Please upload the email below and the attached documents from the applicant onto Ocella for Land at Bridge Cottage & The Old Cottage, Lidsey Road (AL/75/19/PL).

Please find attached a stage 1 safety audit (RSA) in response to the attached comments from WSCC Highways.

scale	1:250 @ A3	drawn by	JME	checked by	KC
date	AUGUST 2019	cad file	FIGURE	suitability	rev. P1
drawing number	FIGURE-1.5

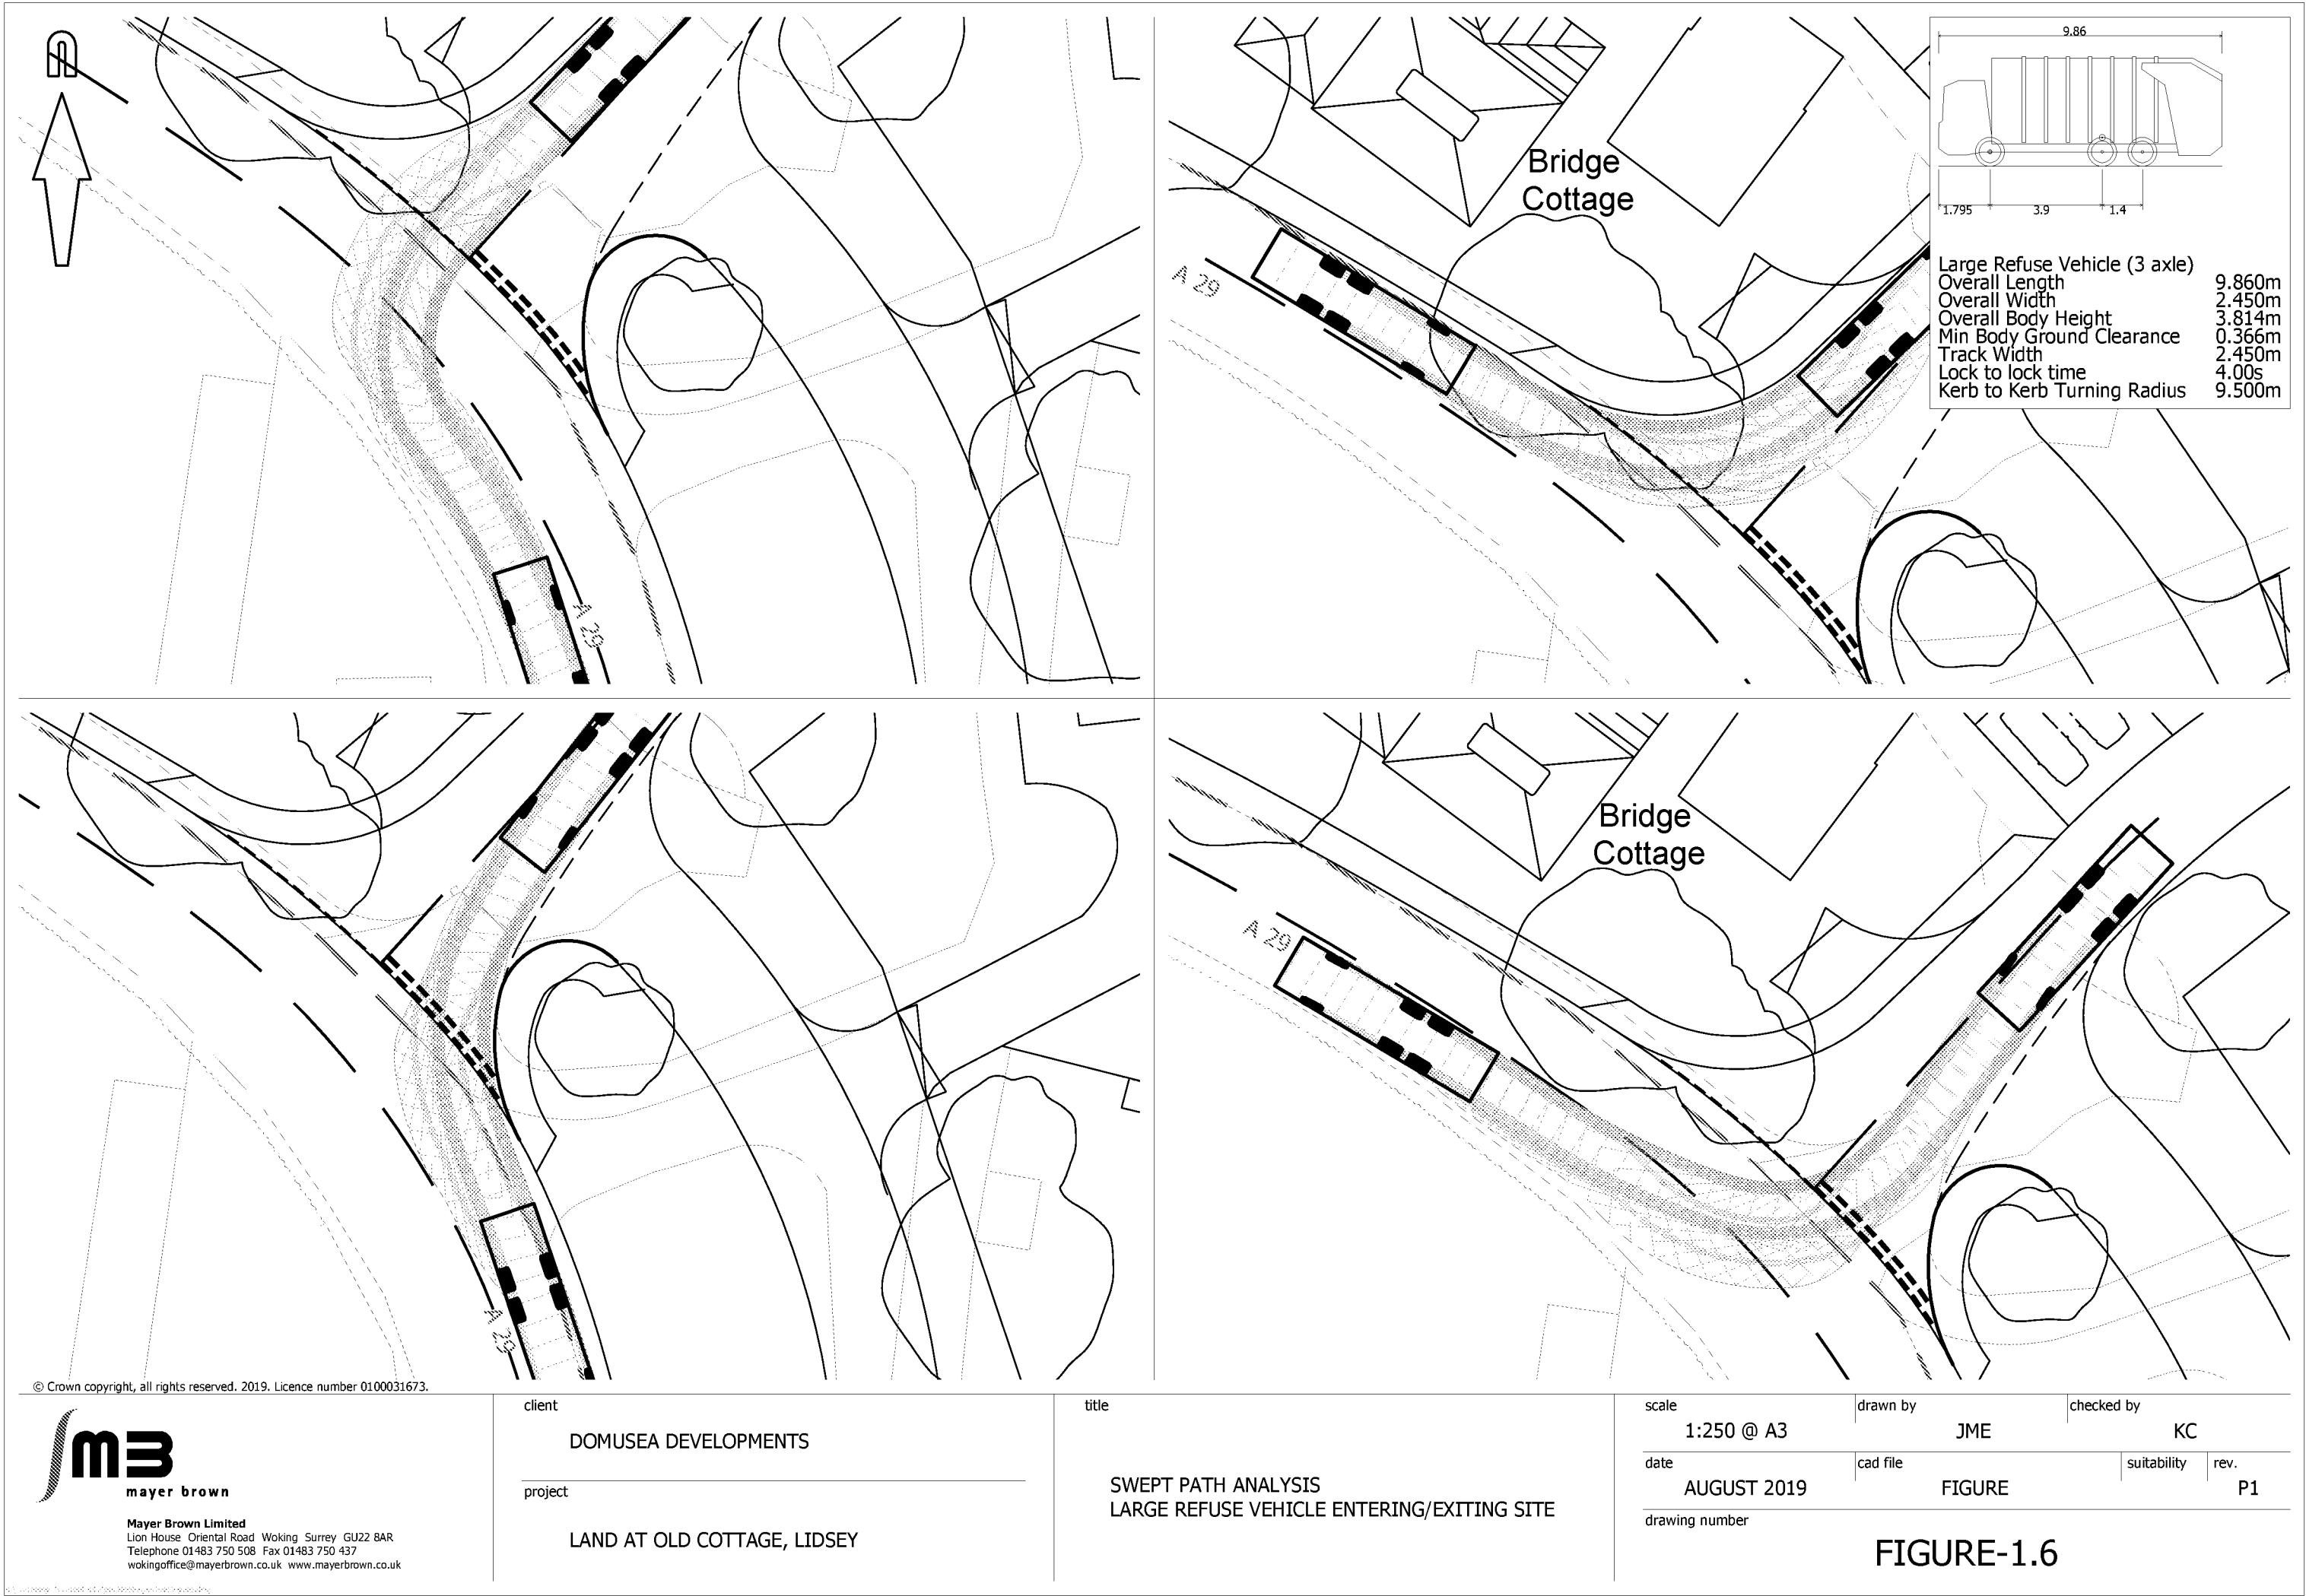
- With regards to site access arrangements WSCC have said on page 2 that Mayer Brown haven't indicated any dimensioning detail of road widths, bell mouth radii, but this is actually shown in Figure 1.5 in their August Technical Note (TN) (this is appended to the RSA). These details are also shown on the revised Figure 1.5 P2 with the relocated access to Bridge Cottage.
- On page 3, under the heading site access visibility splays (and forward visibility), WSCC have the said that forward visibility is reliant on land that is outside of the highway boundary. However, with reference to Figure 1.10 and the highway boundary plan in Appendix C of our TN, we believe that the forward visibility shown can be achieved within highway land so would be grateful if WSCC could review this.
